GRADING AND EROSION CONTROL PLAN

SECURITY WATER DISTRICT

WATER TREATMENT PLANT BUILDING ADDITION

AUGUST 2024 (AMENDED JANUARY 2026)

SECURITY WATER DISTRICT LITTLE JOHNSON RESERVOIR
PROPERTY

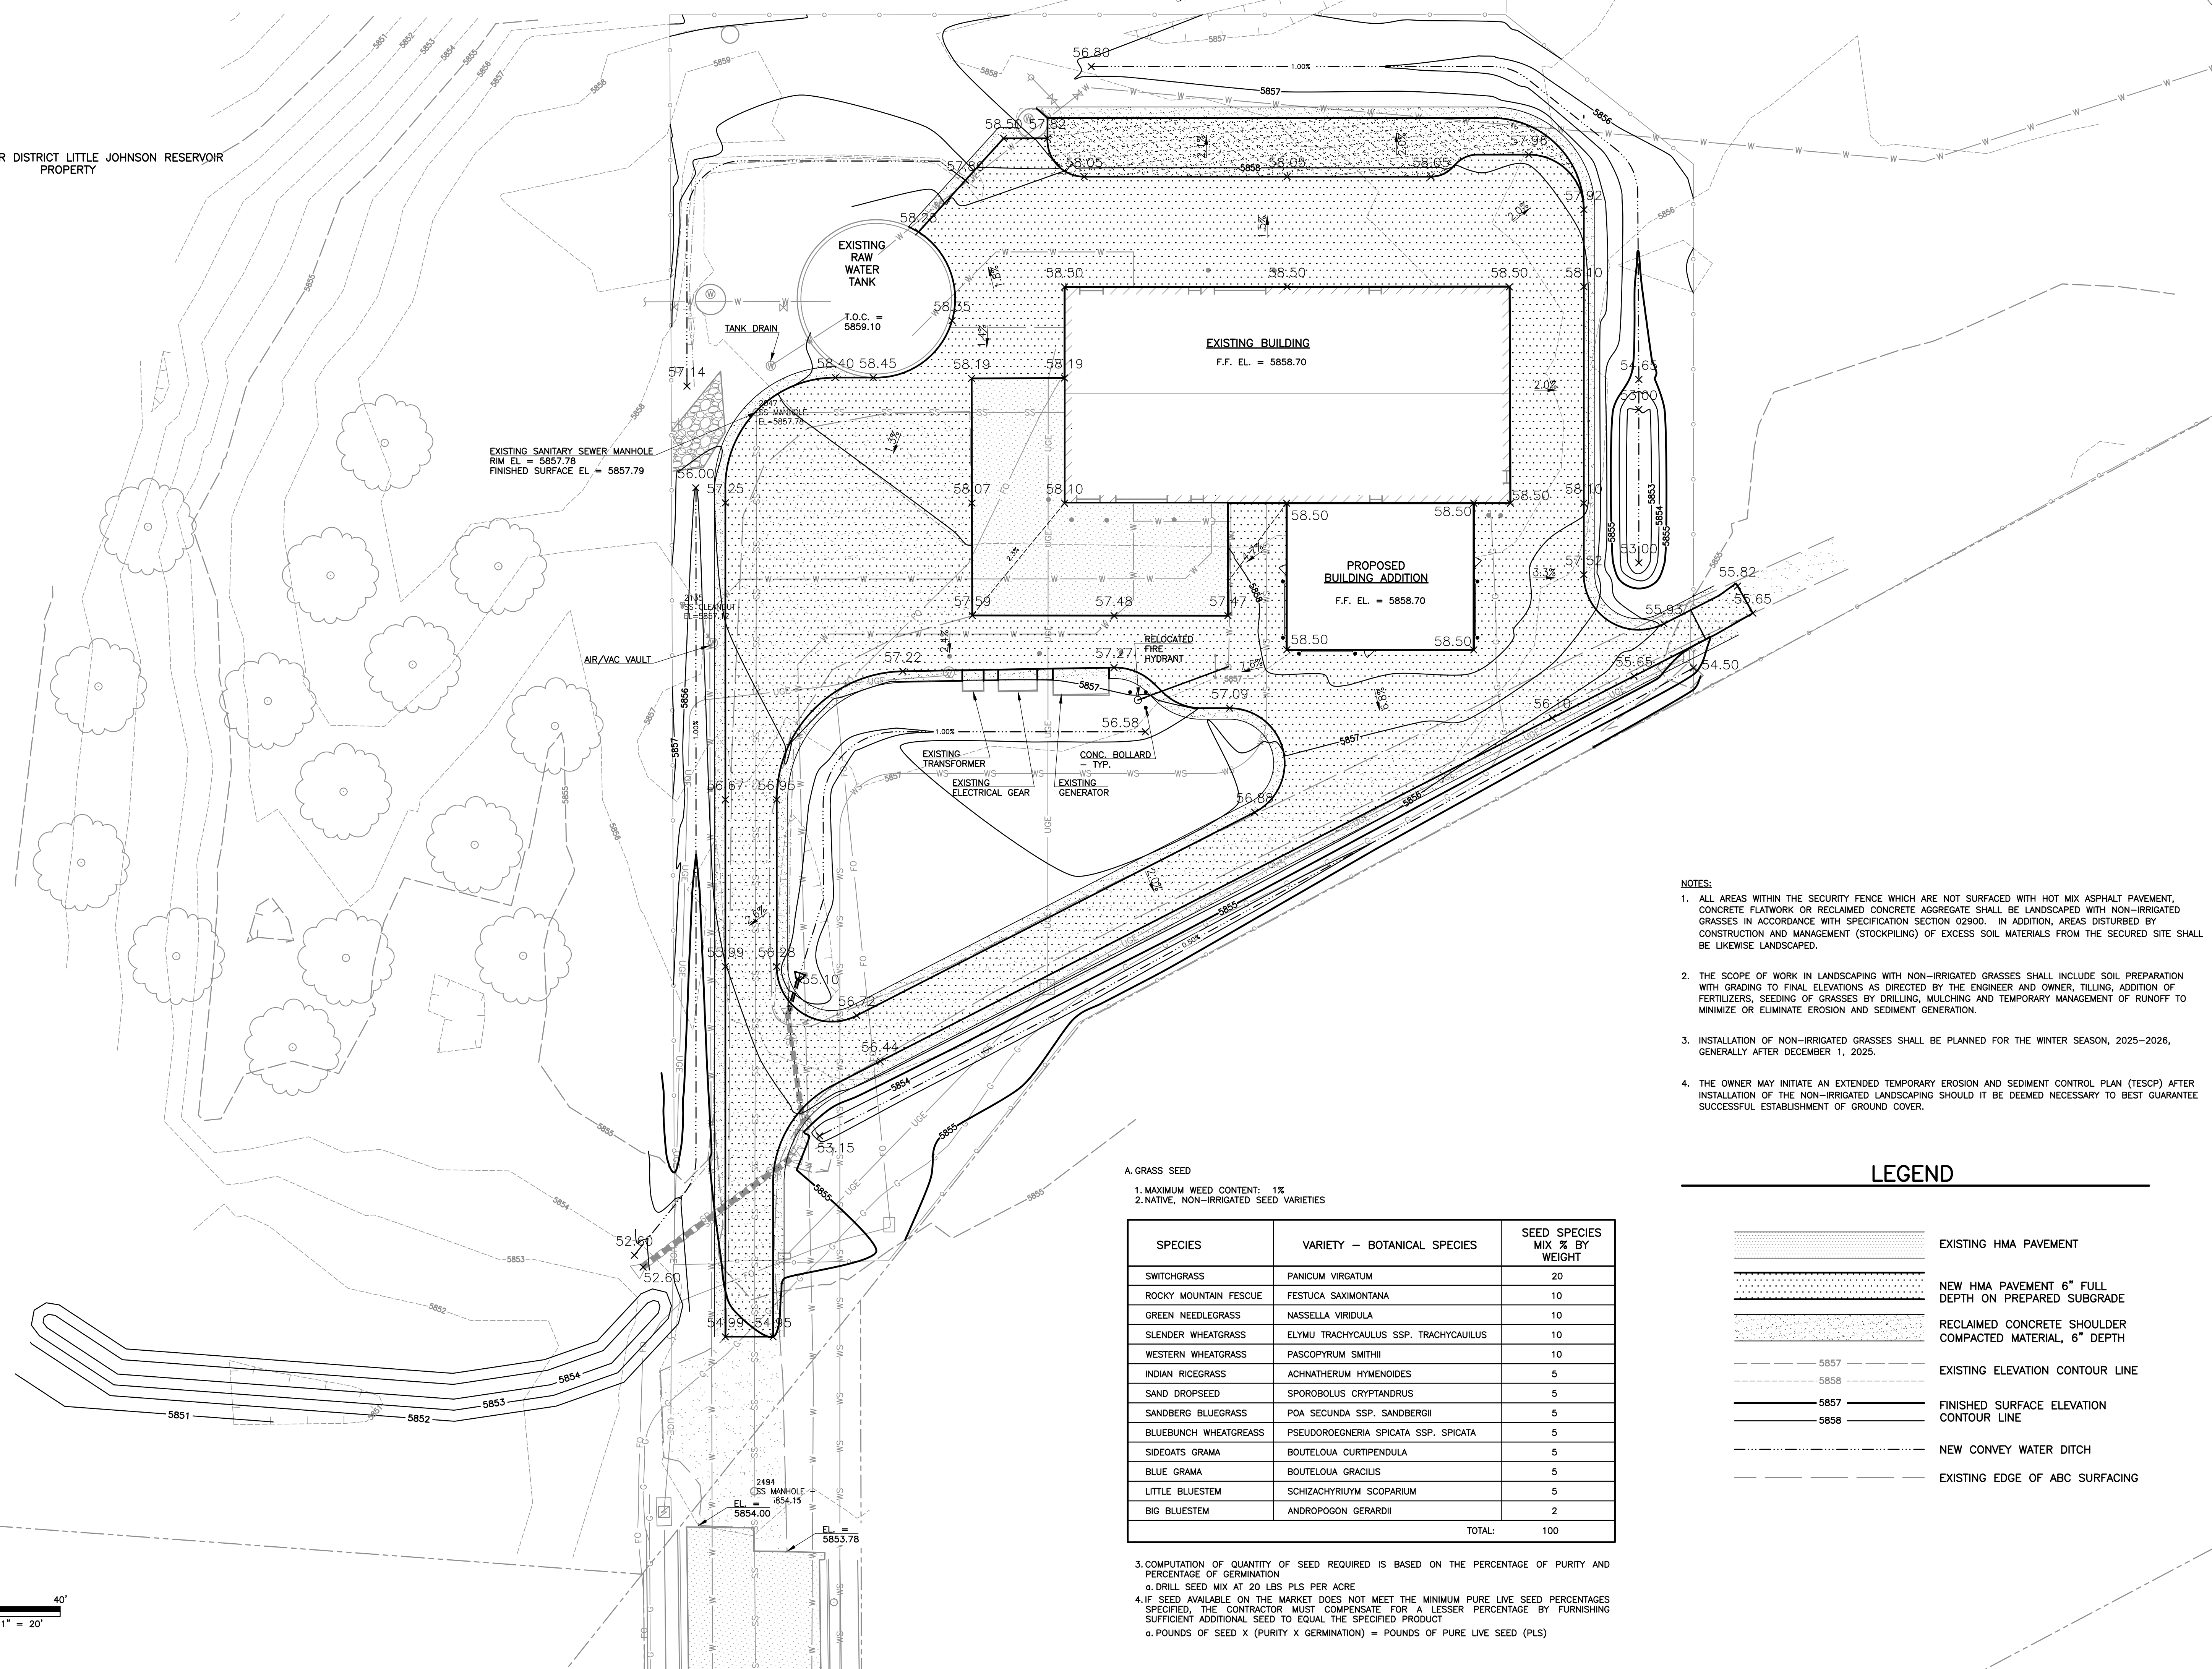
Show all proposed drainage
improvements

Is this area tributary to the rain garden as well? it appears that the swale here will carry flows to the riprap pad.
